From: Sue Howell <Sue.Howell@arun.gov.uk>
Sent: 27 June 2022 15:56
To: Planning.Responses <Planning.Responses@arun.gov.uk>
Cc: Maria Tomalova <Maria.Tomalova@arun.gov.uk>
Subject: Planning Consultation on: WA/50/22/PL

Application ref: WA/50/22/PL

Description: 1 No 4 bed dwelling with detached garage and associated parking (resubmission following WA/8/22/PL). This application is a Departure from the Development Plan and is in CIL Zone 3 and is CIL Liable as a new dwelling.

Location: Land adjacent to Oak Bank Wandleys Lane Walberton BN18 0QR Oak Bank Wandleys Lane Walberton BN18 0QR

Site Block Plan 1:200

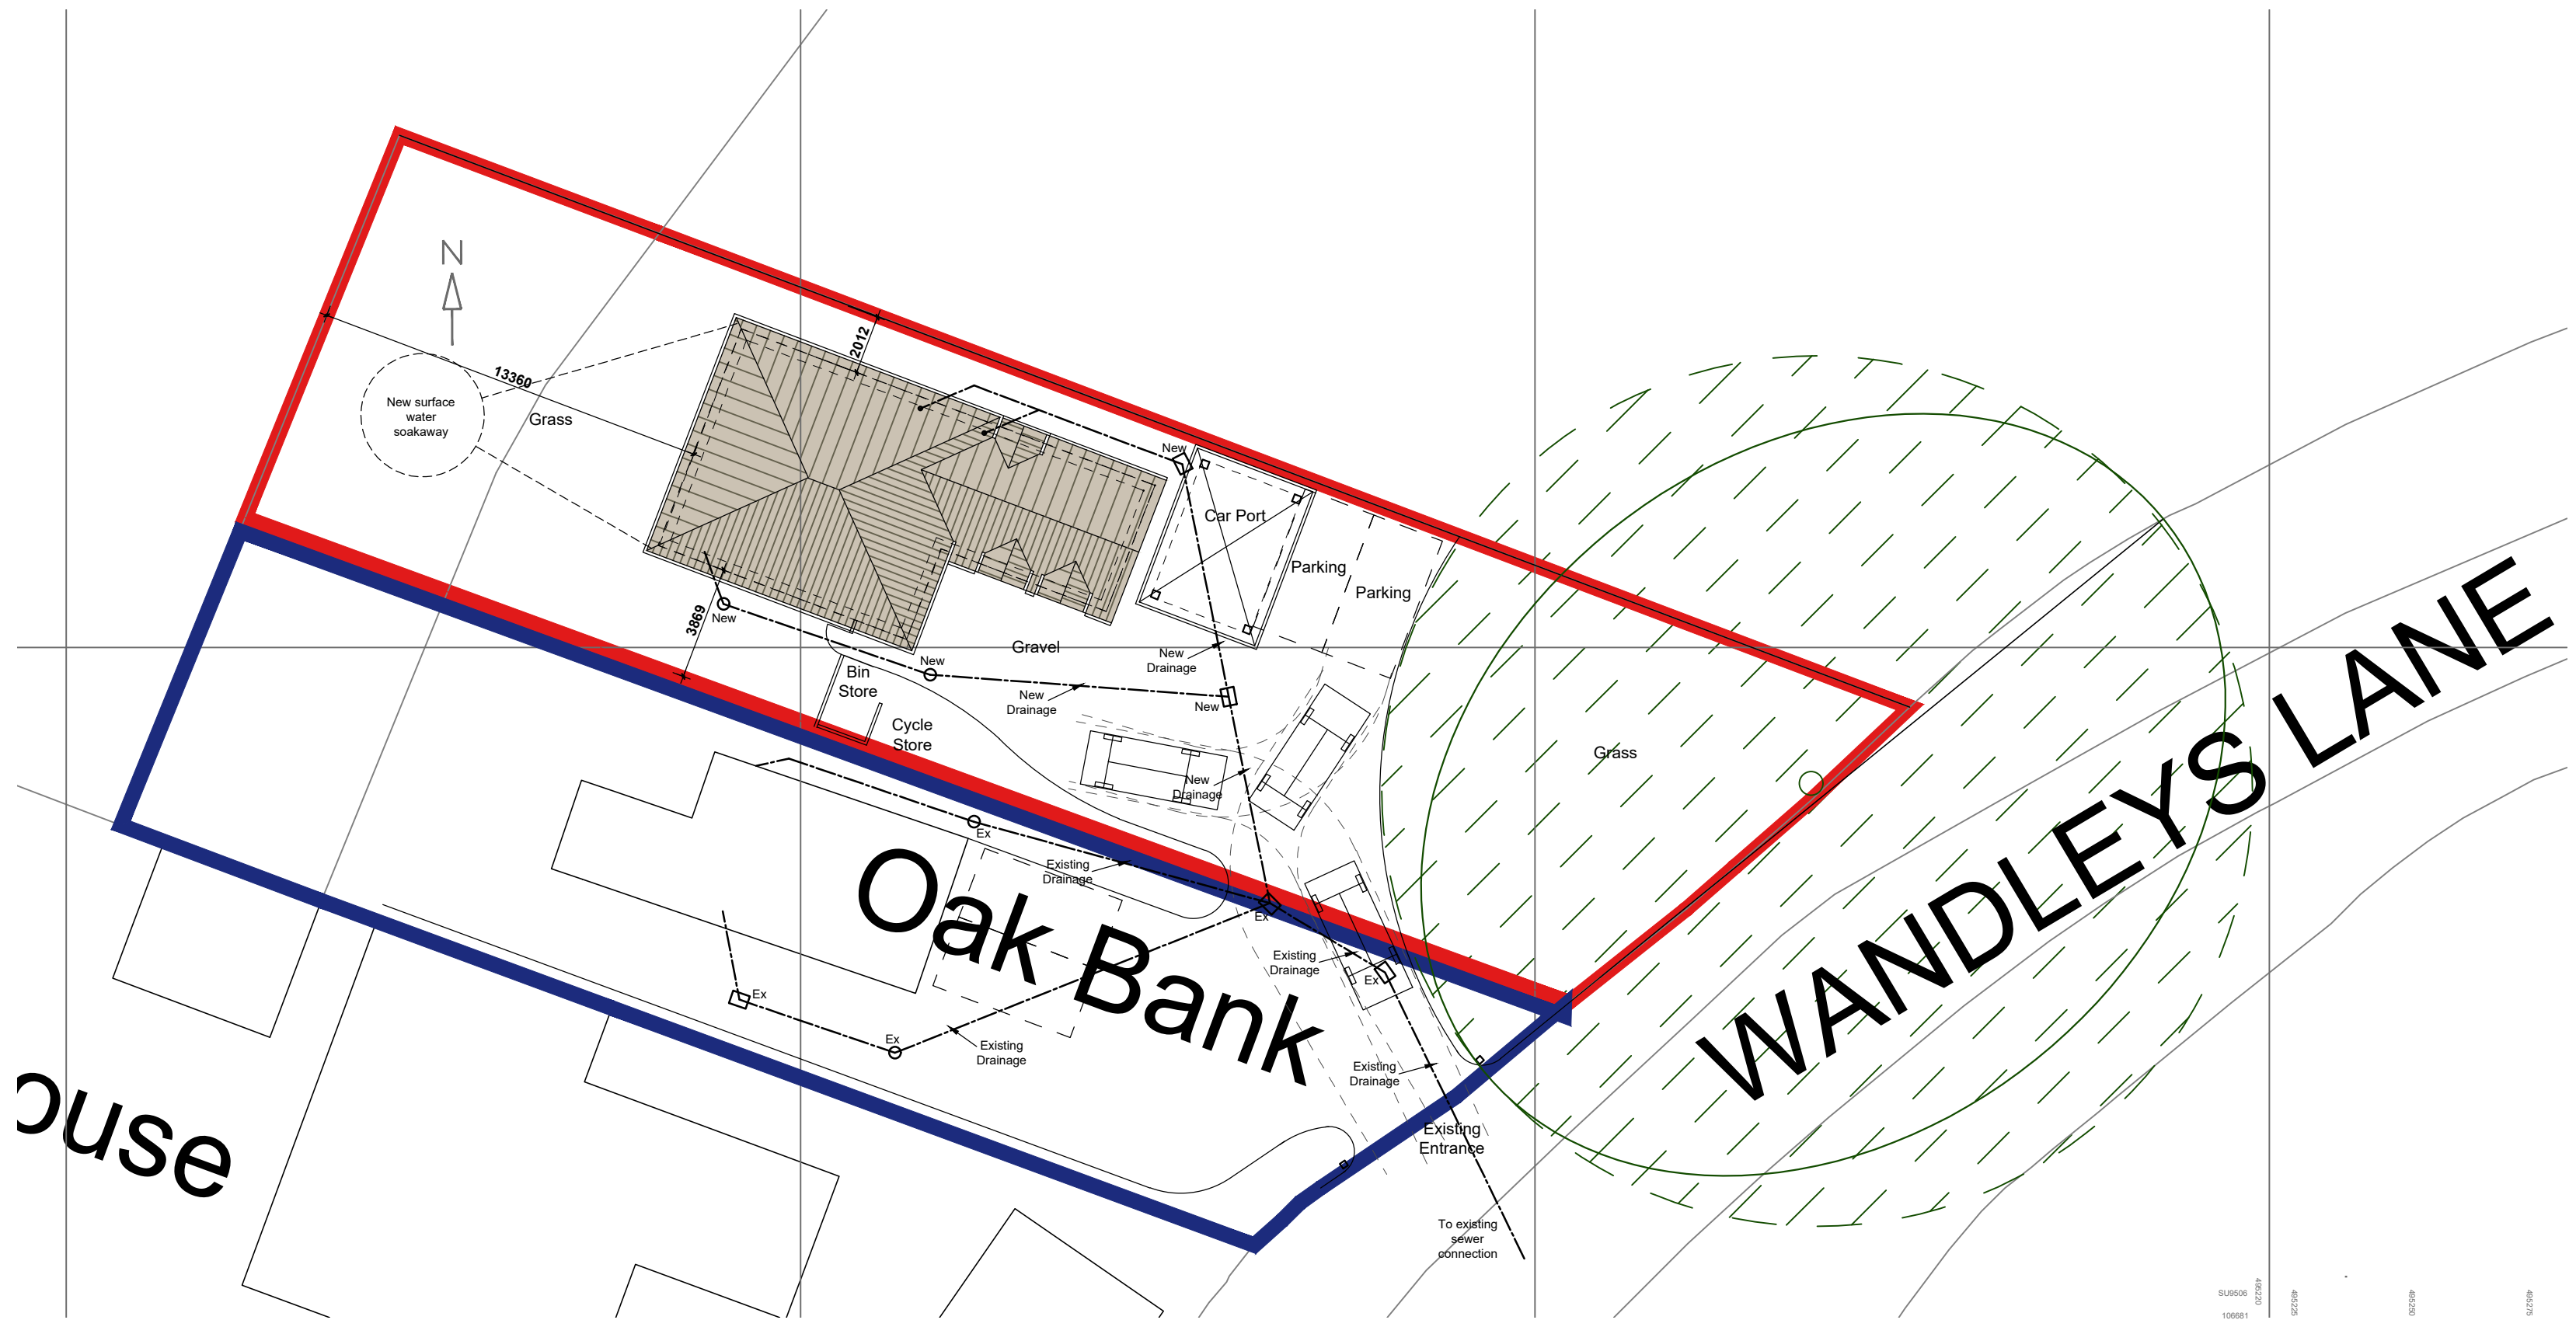
The NPPF para 124/127 relate to good design principles which equally apply to small infill and replacement development. The indicative site layouts and tree protection plans has made reference to tree retention. These details would require expanding in the form of a detailed planting plan and specification detailing species choice, actual plant quantities, planting densities and size at time of planting. Detail should also be provided regarding existing trees and boundary planting.

Landscape provision to the dwelling and improvement with native species infill plus further boundary screening as required. All proposed planting should be considered and its connection for biodiversity and habitat explored, with a biodiversity net gain following development. Trees specified should be at a size which allow instant impact, but which will establish and mature as the site develops.
